Your Ref: Norwich-Tilbury Drainage Strategy Ref: FW2026_0440
Date: 09 June 2026 Tel No.: 0344 800 8020
Email: llfa@norfolk.gov.uk

Norwich to Tilbury: LLFA Review of Drainage Strategy

Thank you for your consultation on the above site, received on 28 May 2026. The LLFA have reviewed the submitted information and have the following comments to make.

Title:  
**Figure 4.2 - Project Description - Proposed Project Design - Permanent Features Section A**  
 Page 1 of 63

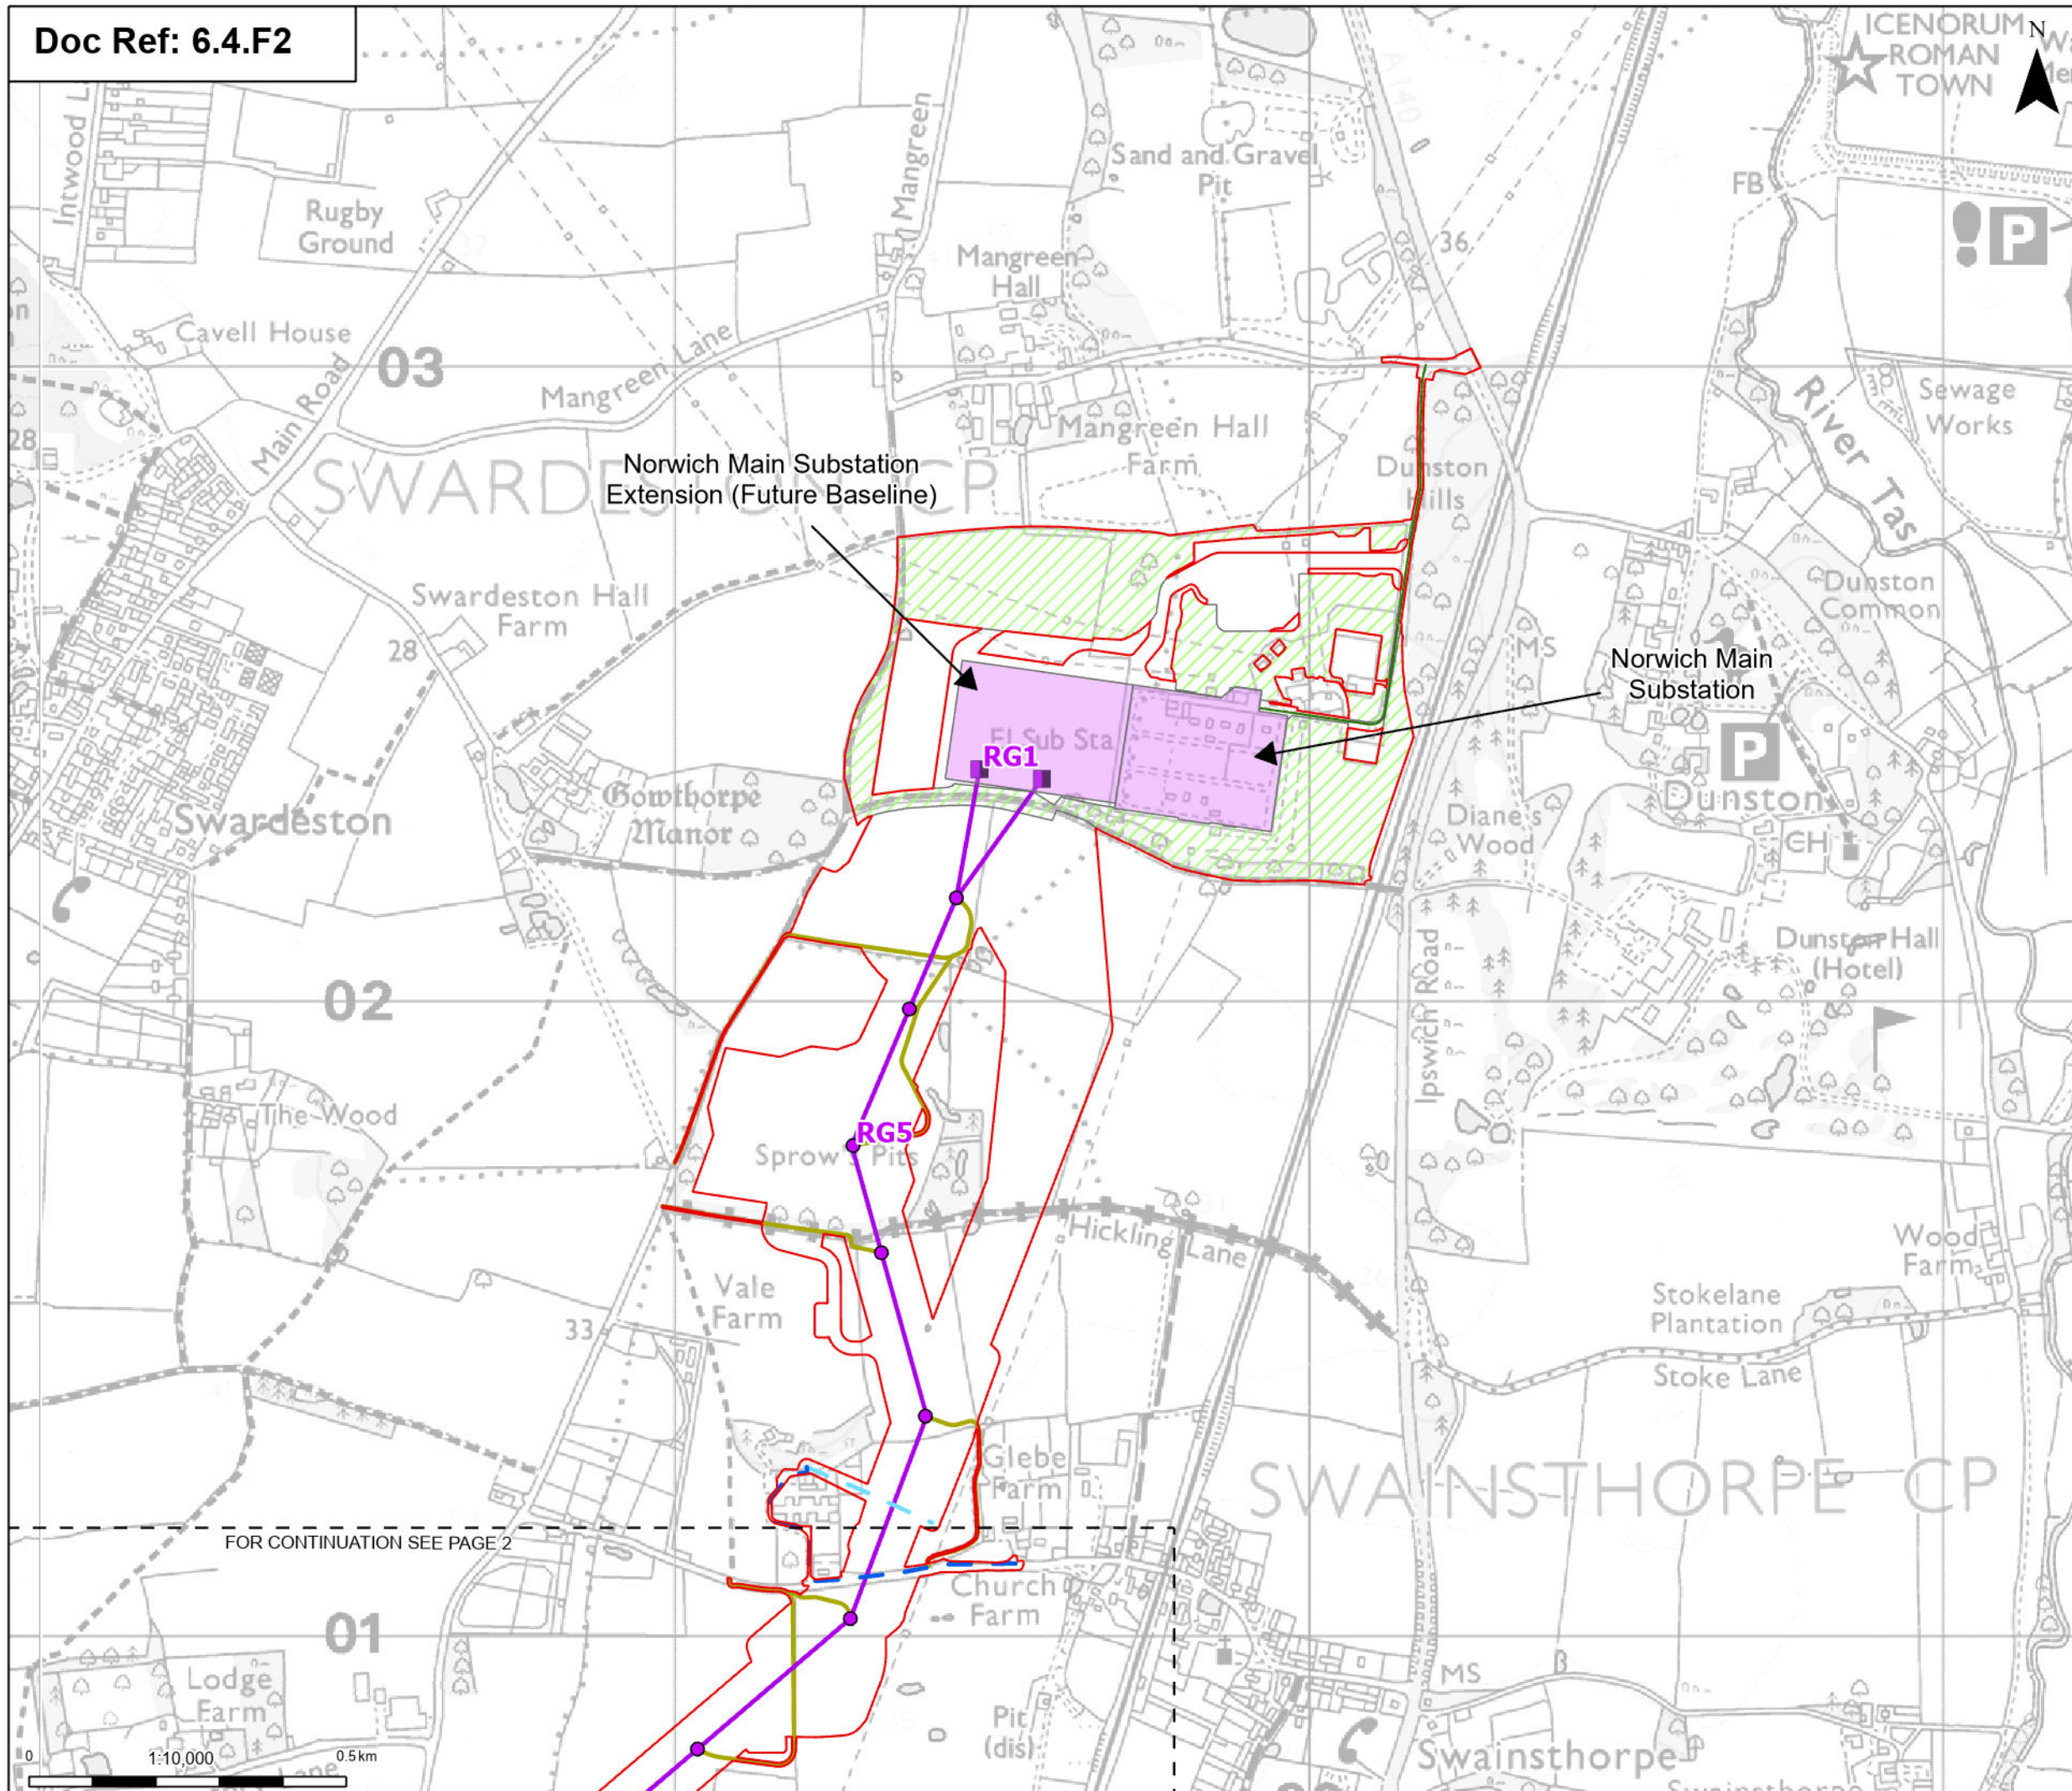
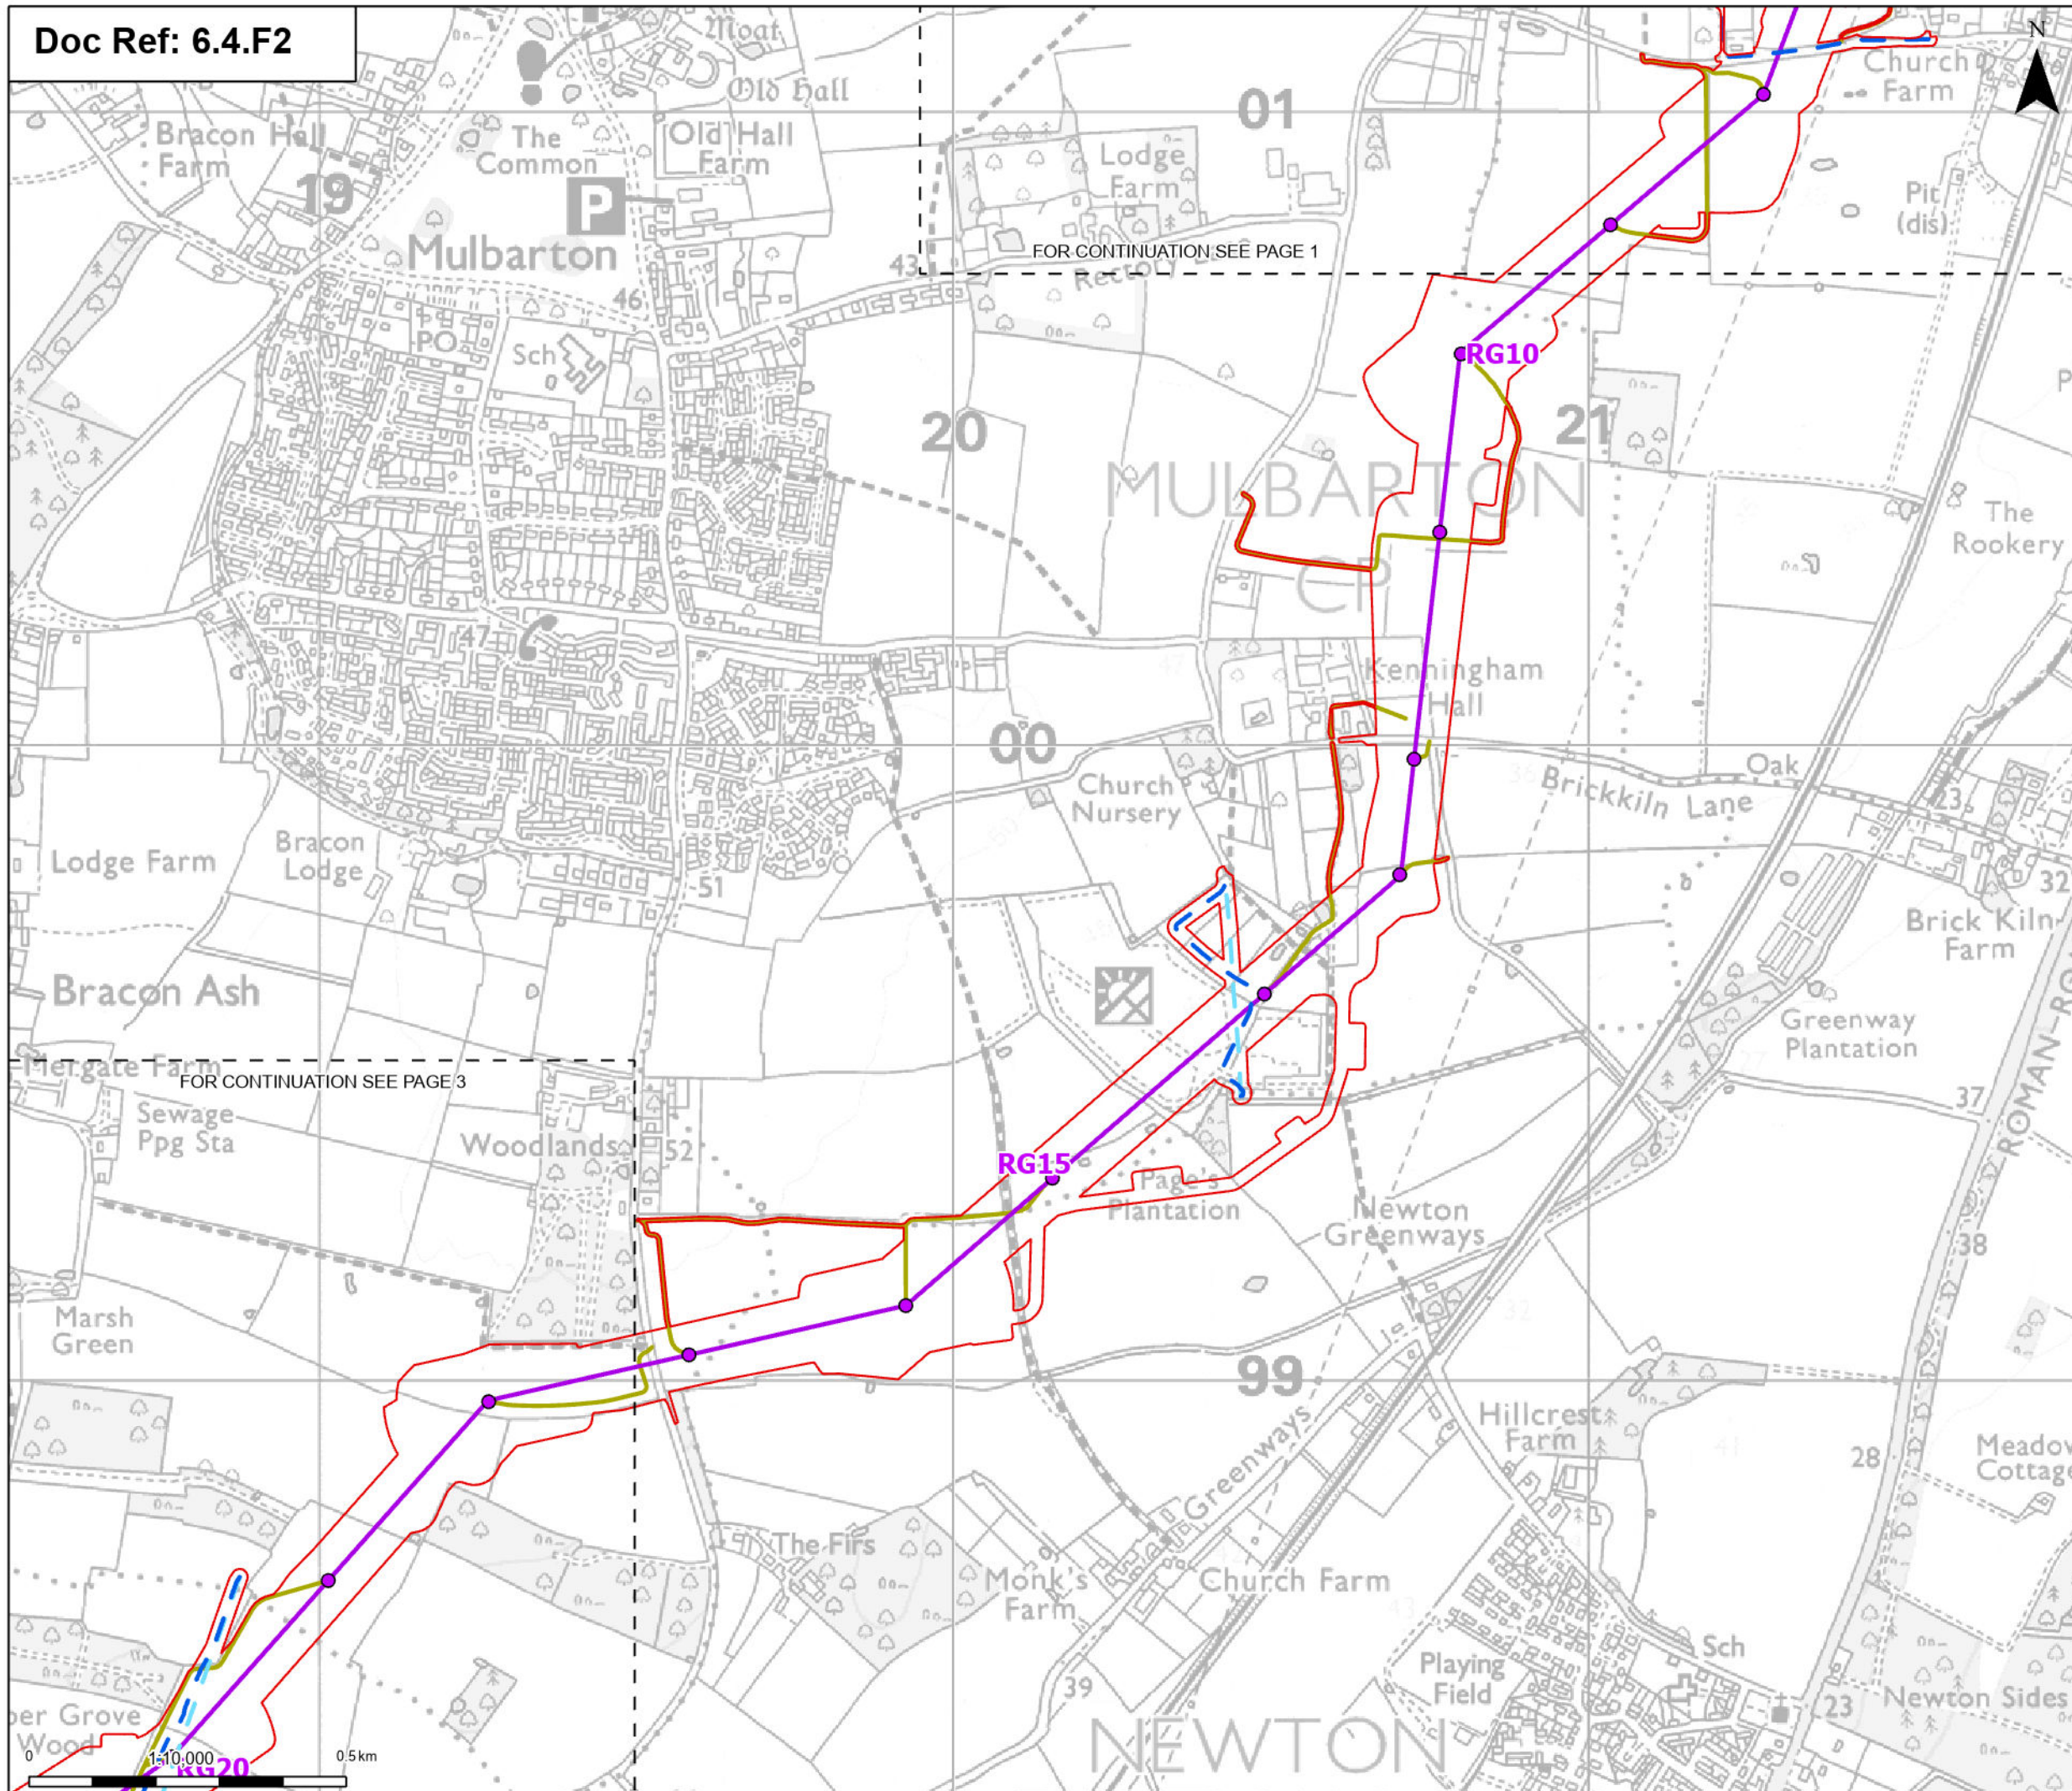
On review of Figure 4.1, Figure 4.2 and Appendix A, it is not possible to make a connection between the information and references provided in the drawings and the information provided in Appendix A. In Figure 4.1, the proposed overhead line construction SuDS basins are the only SuDS features with a symbol on the plans. These SuDS features are not labelled in Figure 4.1. In Appendix A, a pond reference number is provided along with a contributing catchment area. This information is not provided in either Figures 4.1 or 4.2. Furthermore, the order of the ponds appears to not be provided in a north to south approach and is therefore inconsistent with the approach taken in the previous section of the drainage strategy. In Appendix A, there are a number of statements in the "notes/assumptions/risks" section that state "Infiltration of surface water considered unsuitable. Shallow groundwater not identified." followed by a statement of "Infiltration may be deemed possible after infiltration test." This indicates to the LLFA that at present no ground investigation has taken place. Therefore, it is not possible for the applicant to determine whether infiltration is viable. The LLFA Developer Guidance is clear that where in the early stages of design that infiltration testing has not been undertaken, the developer should assume that infiltration is possible as a Plan A approach while demonstrating that a viable Plan B is available. At present, the applicant has not been able to demonstrate that either a Plan A or a Plan B could be viable due to a lack of information. It is also not possible to check or

confirm the whether the proposed discreet drainage catchment area is appropriate and therefore, that the appropriate sizing of the attenuation basin has occurred. Further work and information is required.

LLFA June 2026 Response - Not Resolved - No changes have been made to Appendix A. It continues to not be possible to make a connection between the information and references provided in the drawings and the information provided in Appendix A. Further work and information is required.
